CITY OF ALBUQUERQUE

Planning Department
Alan Varela, Director

Project Title: Tierra Buena Townhomes **Building Permit #:** _____ **Hydrology File #:** C11D002
DRB#: _____ **EPC#:** _____ **Work Order#:** _____
Legal Description: LOT 1 VOLCANO CLIFFS SUBDIVISION UNIT 26
City Address: 99999 ROSA PARKS ROAD N.W.

C1

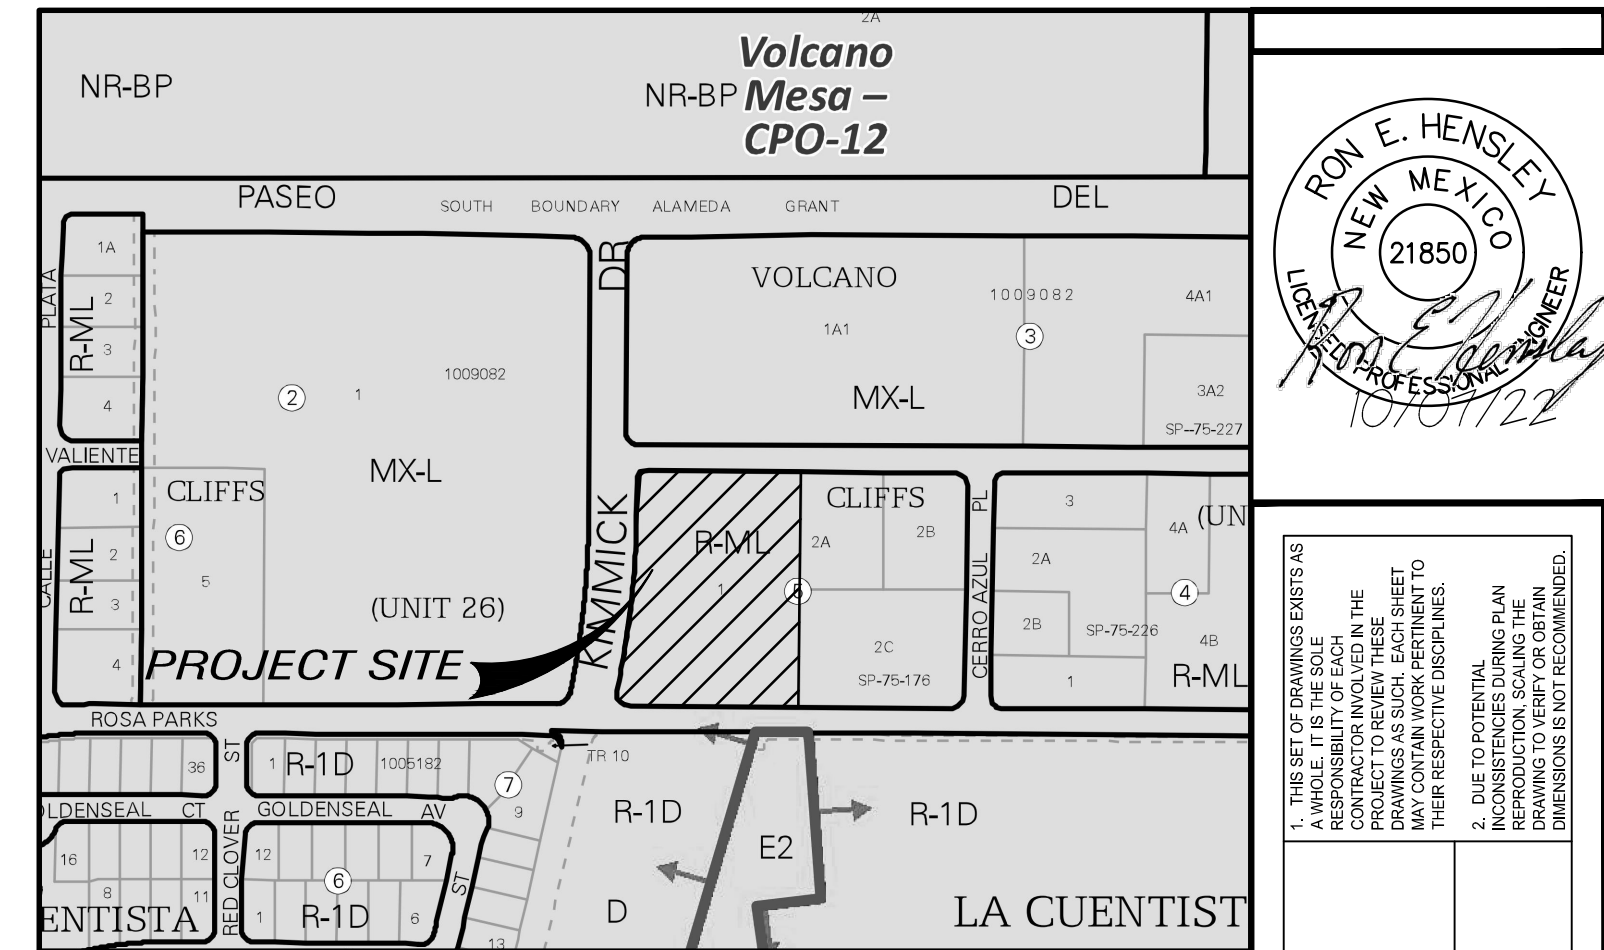
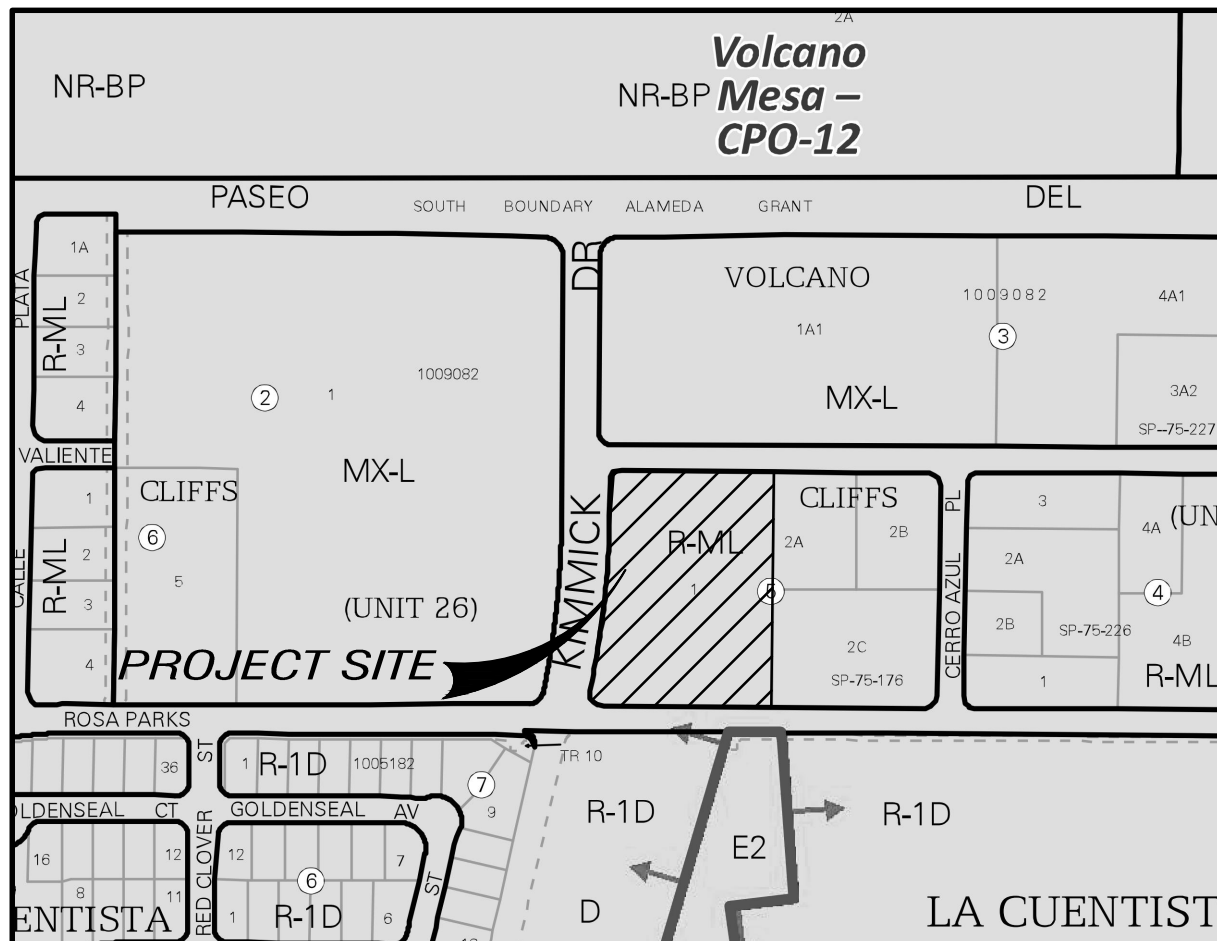
2. Please show existing 48" storm drain on Rosa Parks and the existing detention pond on City property. I have attached the as-builts that show the 48" storm drain and pond.

3. Per Comment #1 (the giving of 6 feet to Rosa Parks R.O.W.), the proposed inlet can be installed with 18" RCP to the existing manhole.

4. Please call out all the adjacent roadways with R.O.W. on Sheet C1 & C2.
5. There are currently three different Drainage Master plans which actually conflict with one another for this property. Below is current watershed for the existing 48" and detention pond on City property.
